From: Laura Gibbons <Laura.Gibbons@arun.gov.uk>
Sent: 31 August 2021 09:38
To: Planning.Responses <Planning.Responses@arun.gov.uk>
Cc: Maria Tomalova <Maria.Tomalova@arun.gov.uk>
Subject: AL/90/21/DOC -- Land West of Fontwell Avenue 1 Fontwell Avenue Eastergate PO20 3RU

I have had a look at this in Sarah's absence. I have the following comments on Condition 3:

PROPOSED SITE PLAN PURSUANT TO CONDITION 3
SCALE 1:200

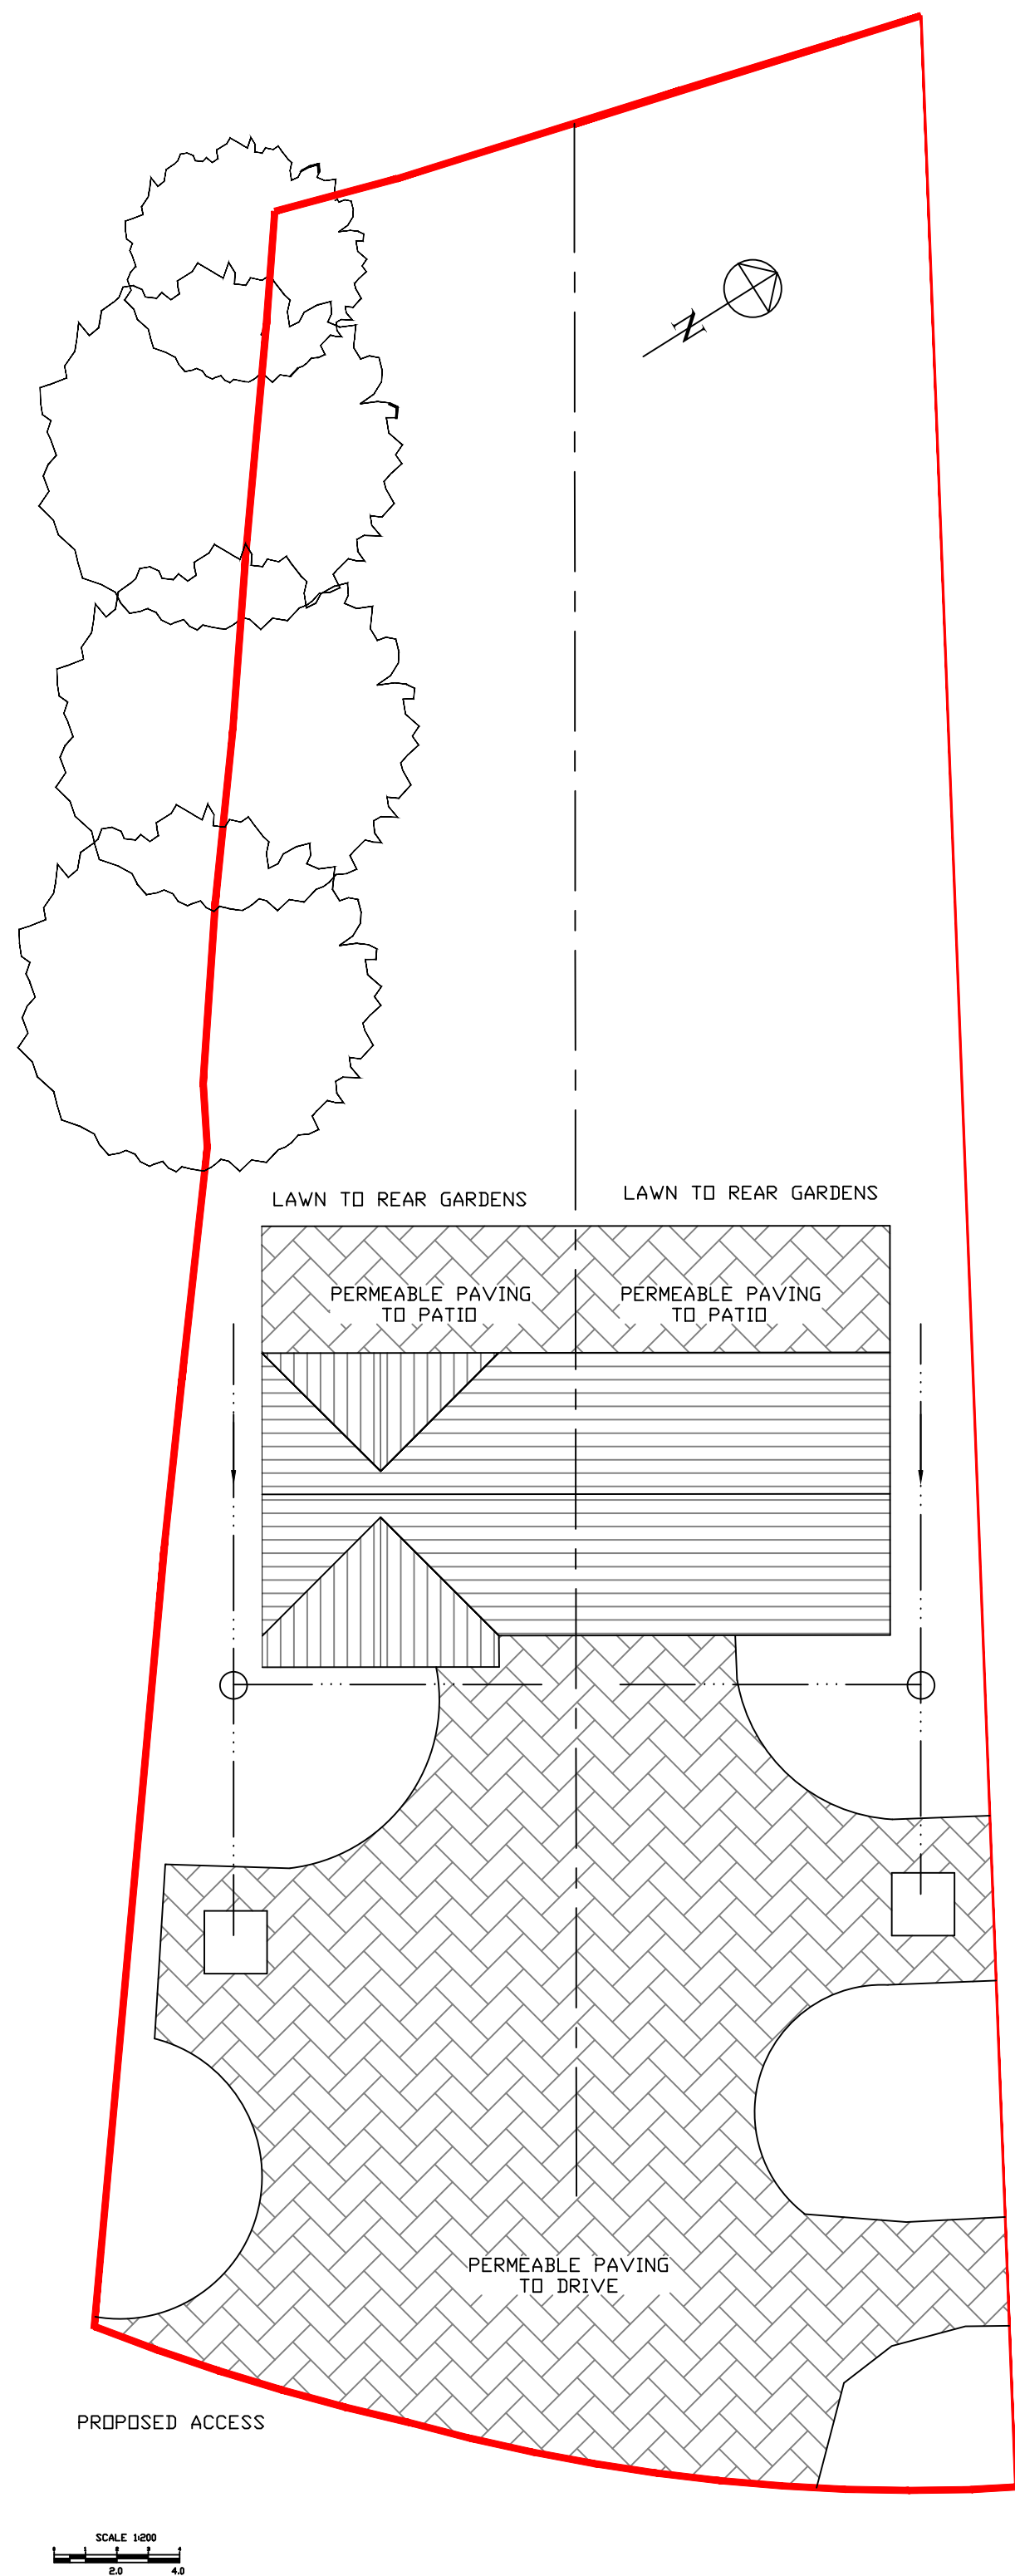
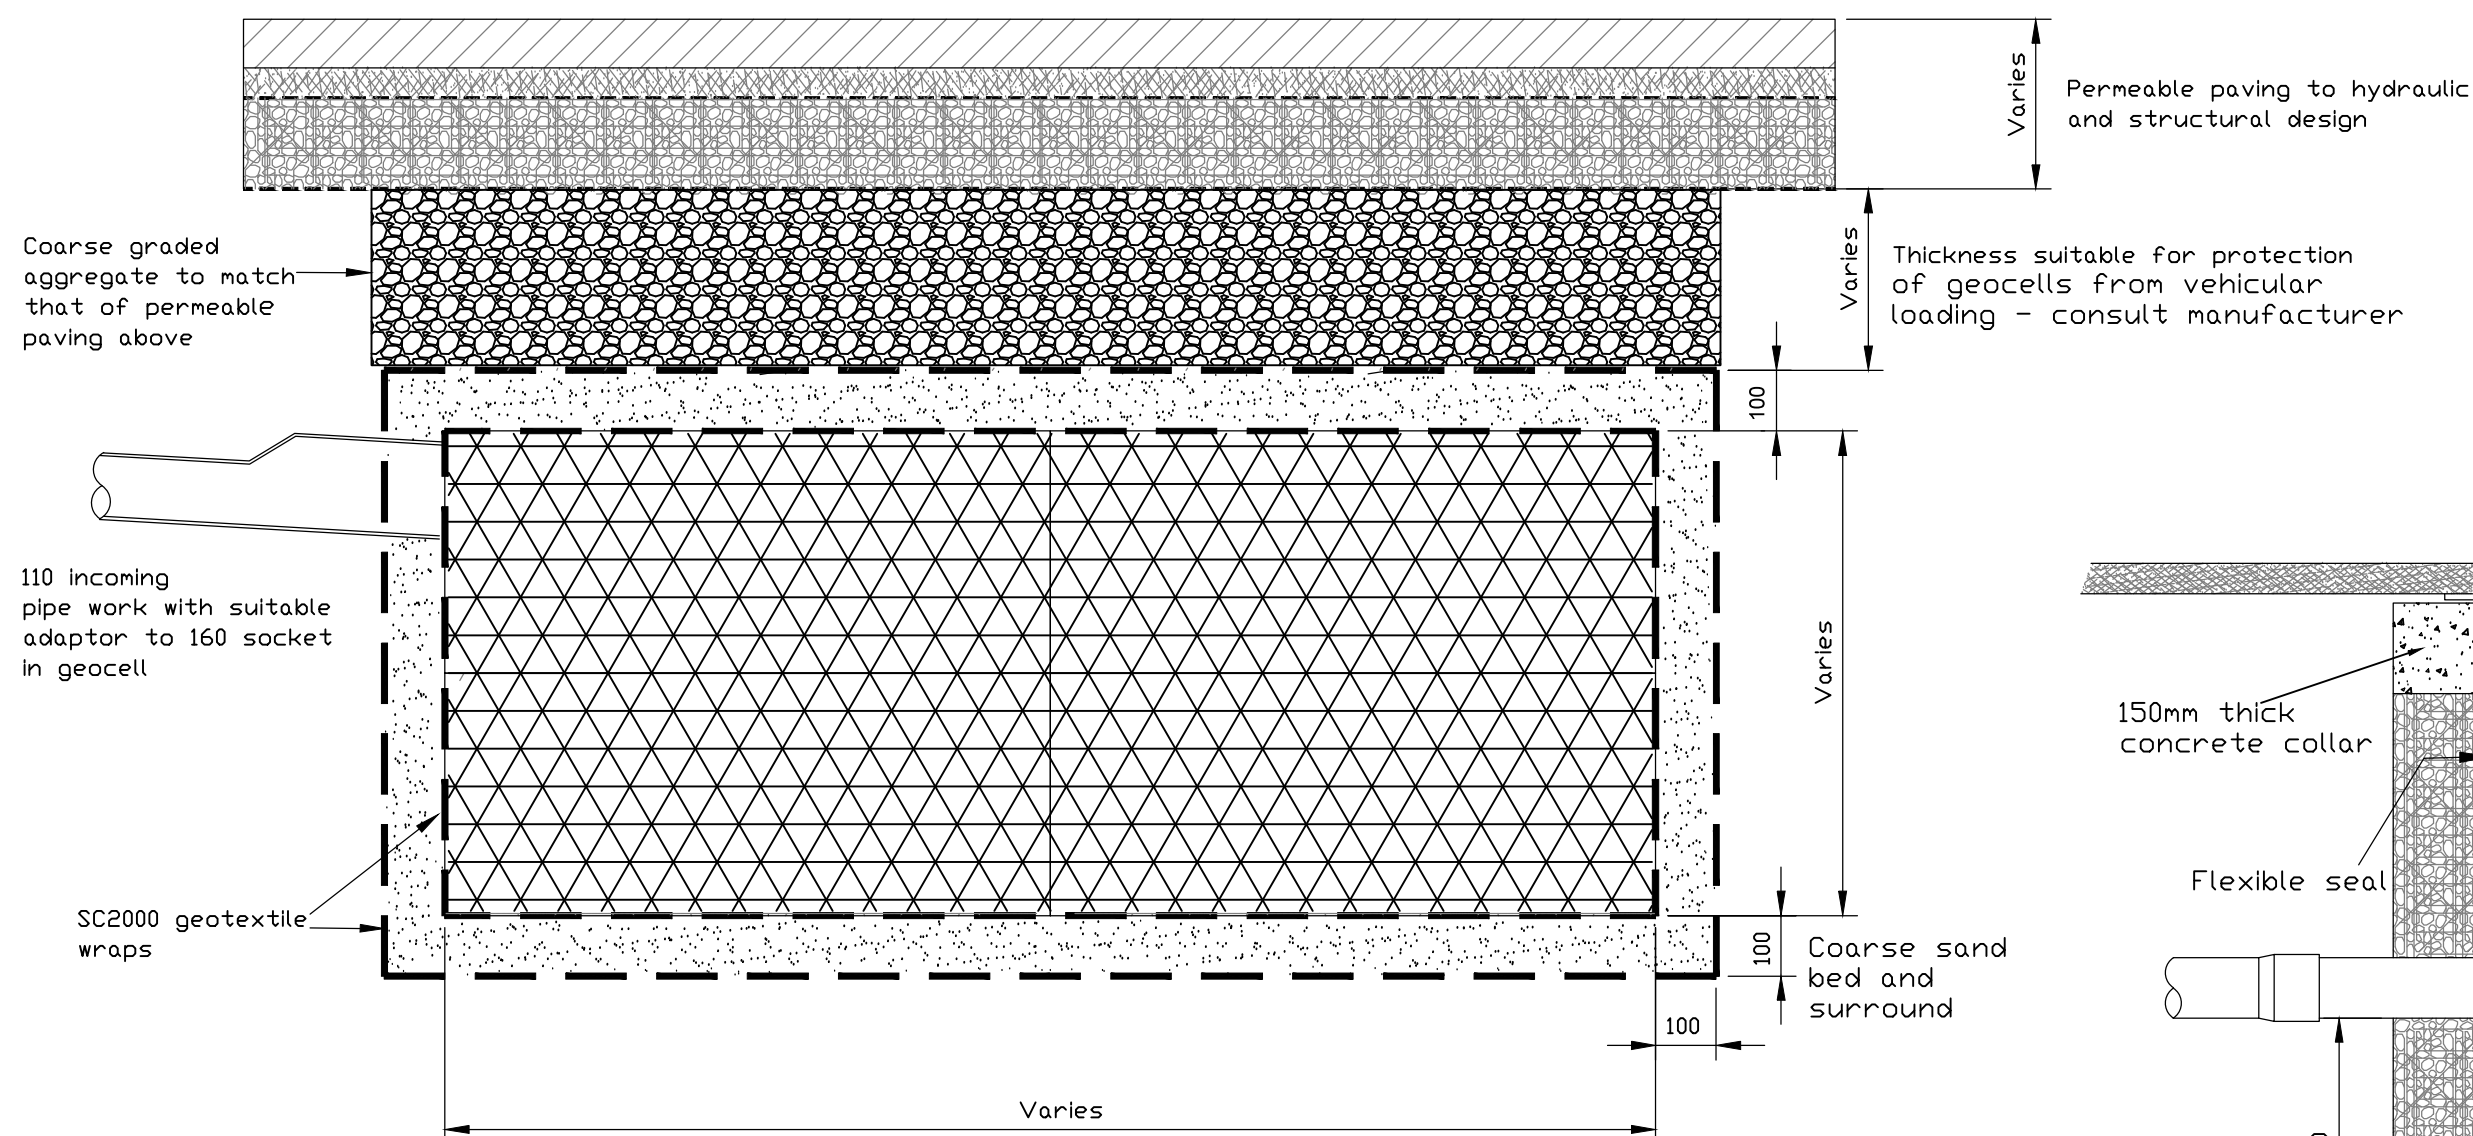
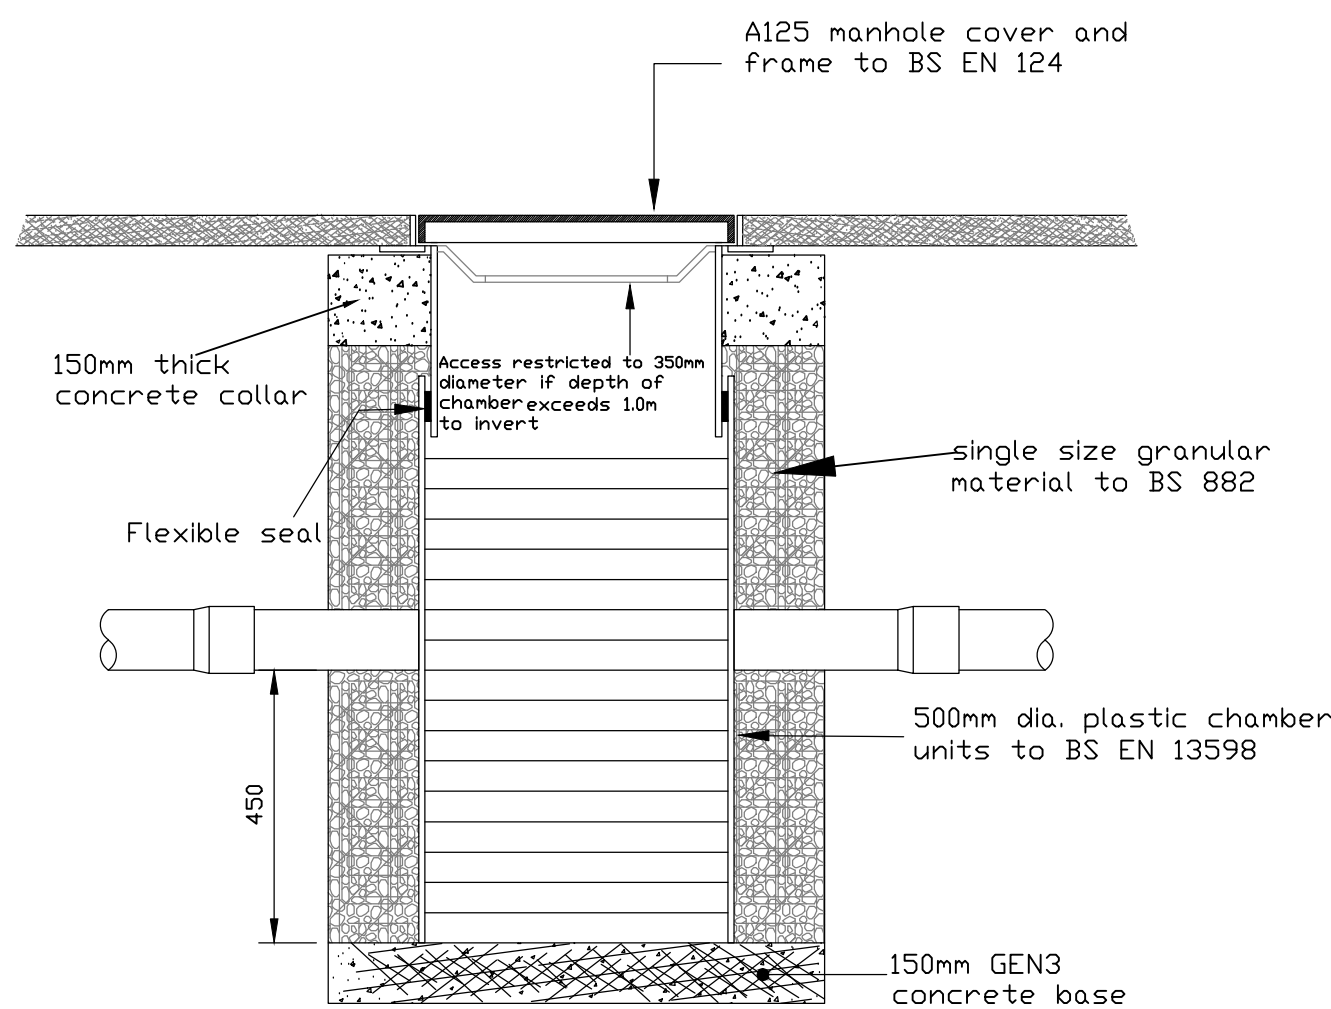
- The surface water drainage layout drawing notes state infiltration between $1.66 \times 10^{-6} \text{m/s}$ and $1.226 \times 10^{-4} \text{m/s}$. The calculations use $5.633 \times 10^{-5} \text{m/s}$, please provide justification as to why this rate has been used in calculations.
- Please can further details of the previous ground investigations be provided. E.g. dates, dimensions of test pts, locations of test pits, etc.
- Please can finish and formation levels be labelled on plan.
- Please can the type of aggregate be labelled on the construction detail drawing.
